EN010127- Application by Mallard Pass Solar Farm Limited for an Order Granting Development Consent for Mallard Pass Solar Project

ISH 2, Environmental Matters, written response to oral submission

Submission by John Hughes ref ID. 20036141.

ISH 2, Environmental Matters

DWG. NO. 7863_PP_007_C REV: P0

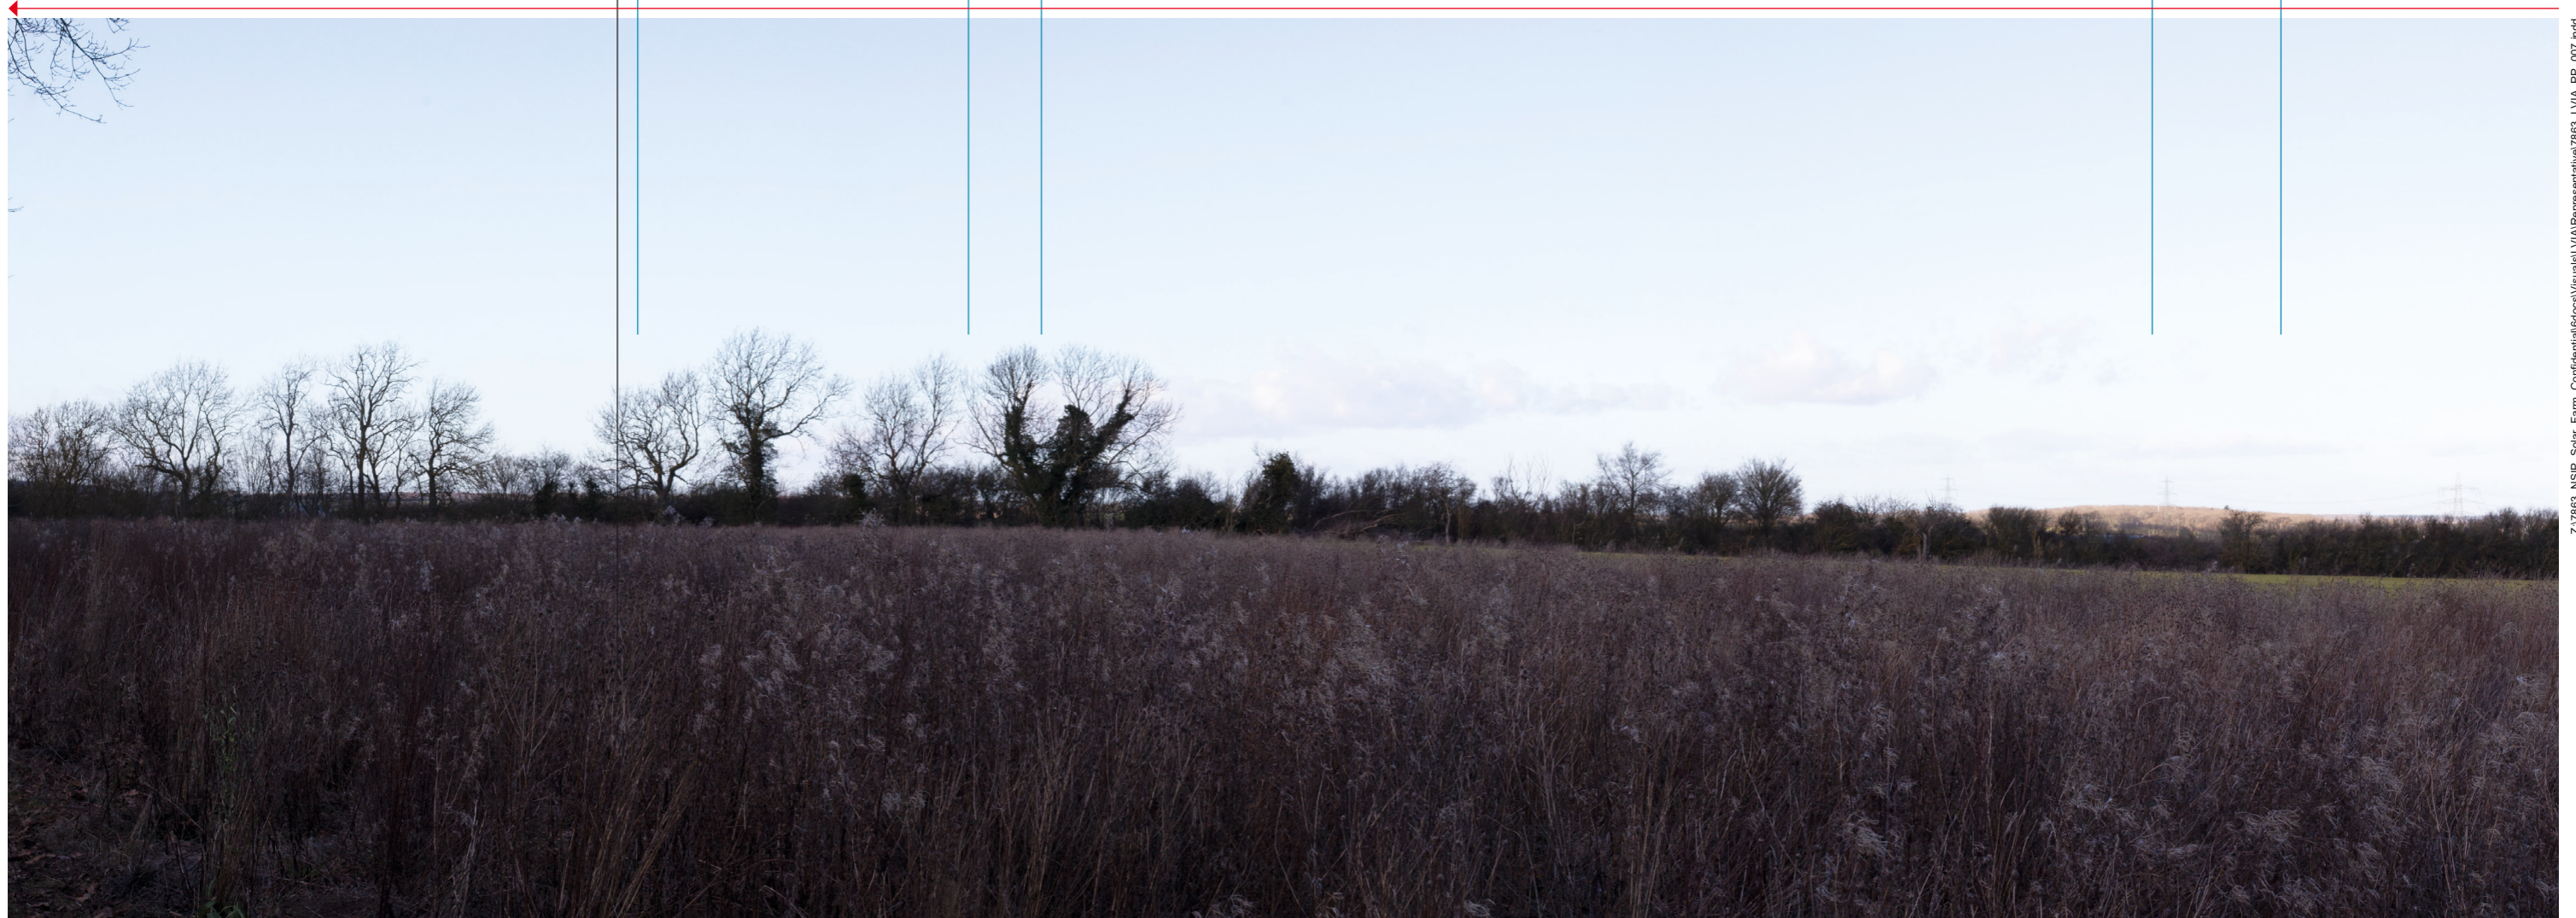
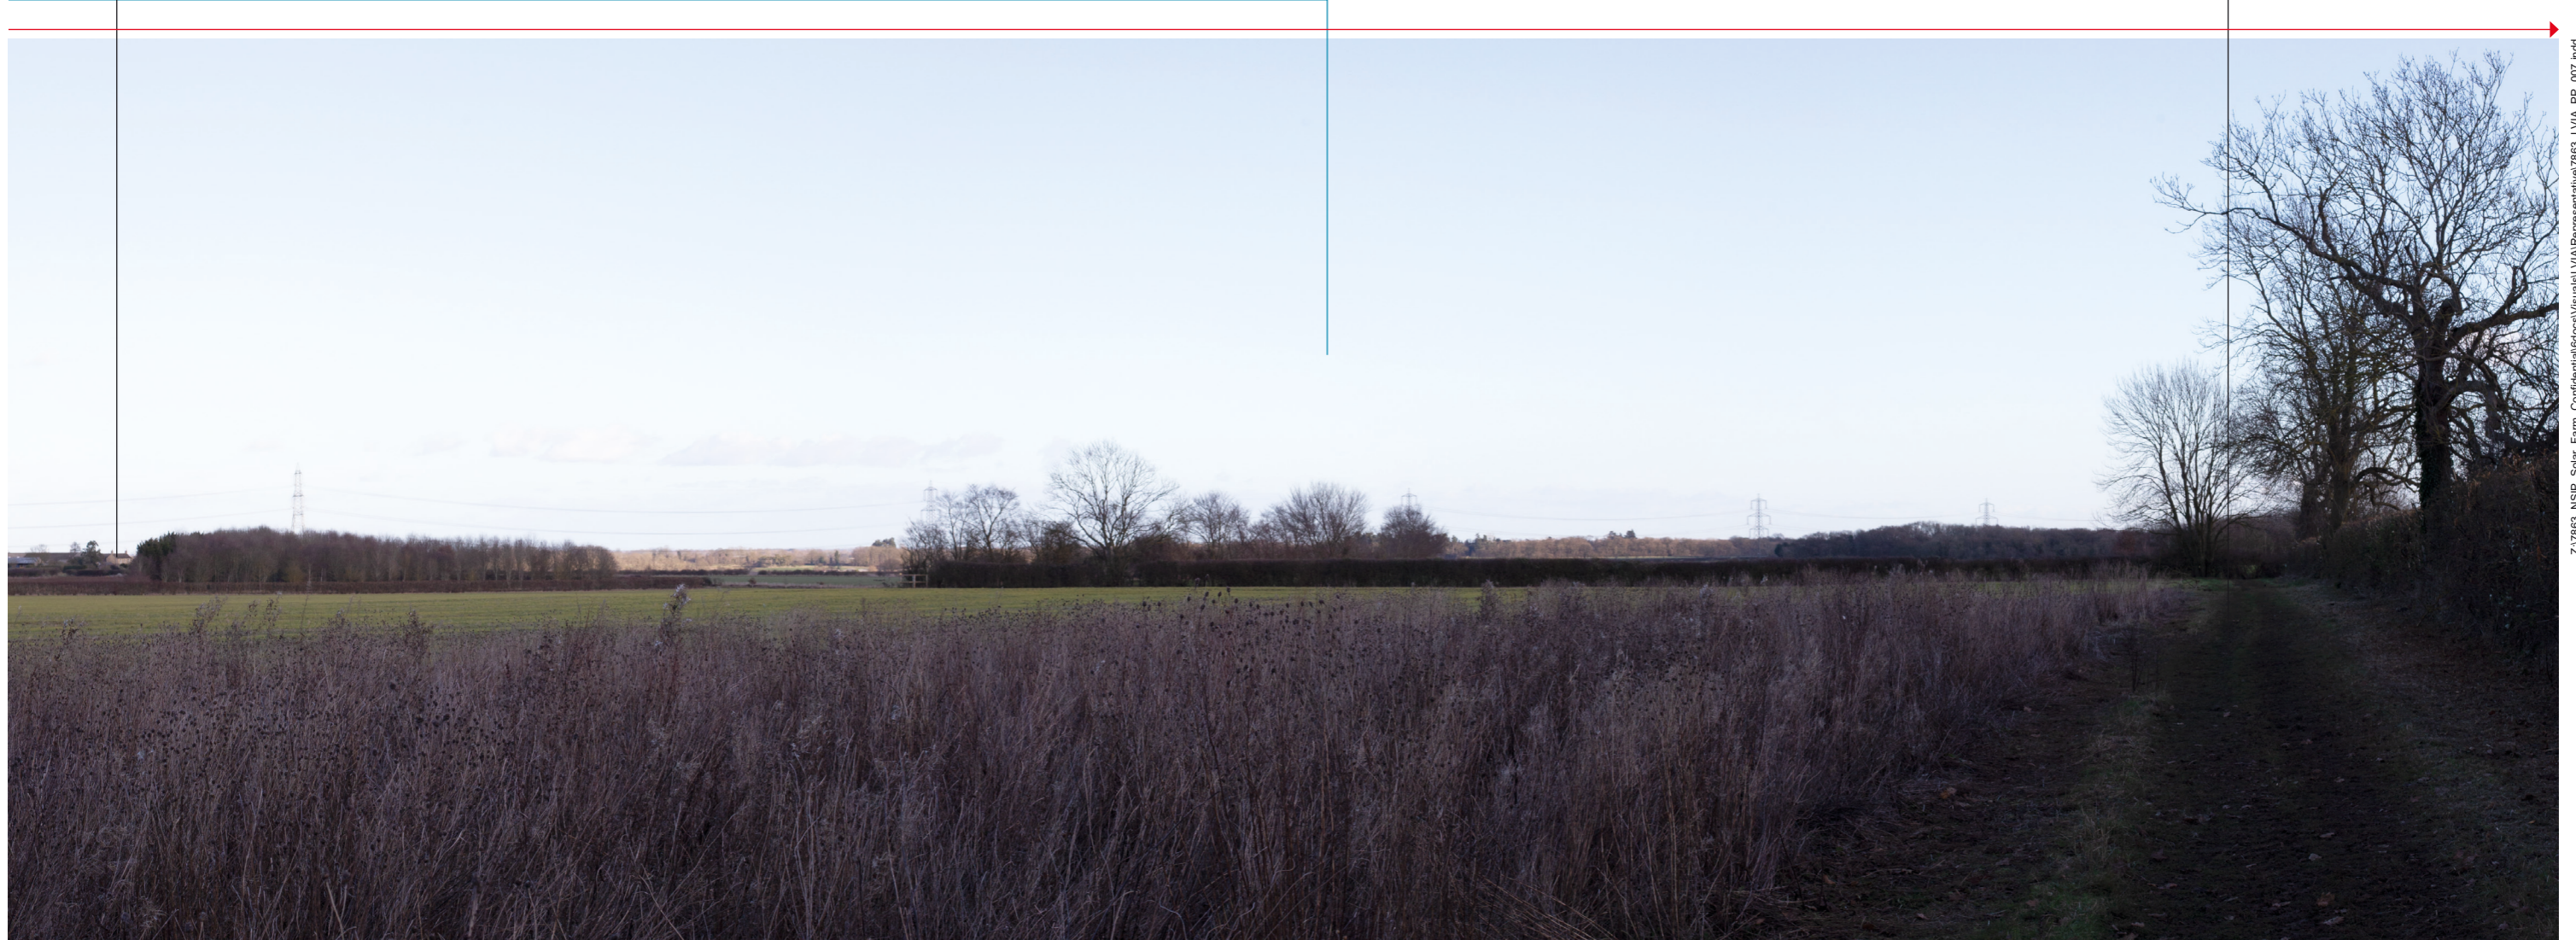
The Photomontages need to be represent seasonal changes because the photograph shown (VP11 Photomontage) does not show the true visual impact because of the time of the year the photo was taken which I believe was 32 days after the winter solstice.

Seasonal photomontages need to be represented as the topography will change with the seasons and Jun/July it can still be light at 9pm. Unless you were a resident to a local property the village or knew to local environment you would not know a substation exists in the photomontage, so if the photomontage is being presented to someone else who is not local they are not able to appreciate or see the true visual effect because of the season and time the photo was taken.

The applicant says the photomontages are to represent the worst case scenario with no foliage however with the seasonal change when the field becomes gold (*if it was planted with wheat*) and the background becomes green the visual effect becomes greater because of the colour of the buildings and structures.

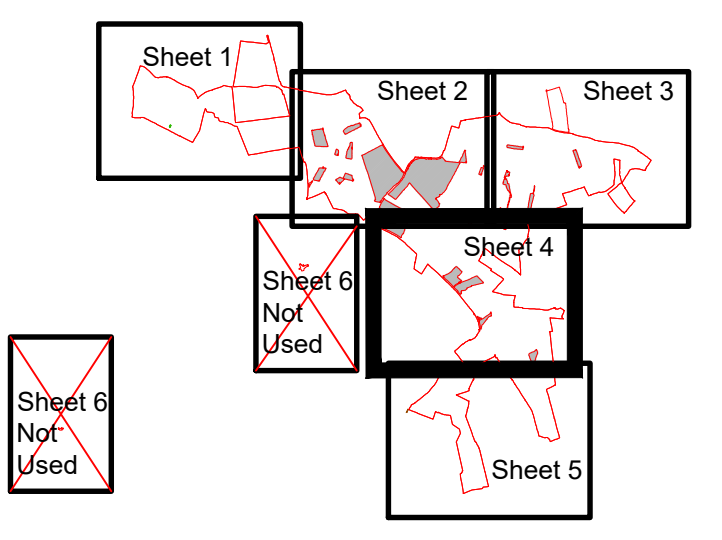
One of the proposed permissive footpaths is running up the side of the ECML and if you were walking to it using the foot bridge over the ECML line on the left hand side of you would be the railway embankment and on the right would be the field of PV arrays, with the regards to the openness and attractiveness of the footpath it would not be something you would want to walk along because even as train spotter you would not be able to see a train

as you would be looking up the embankment. So is there any benefit to the local community and would they actually use them as the end destination is the Essendine Industrial estate.
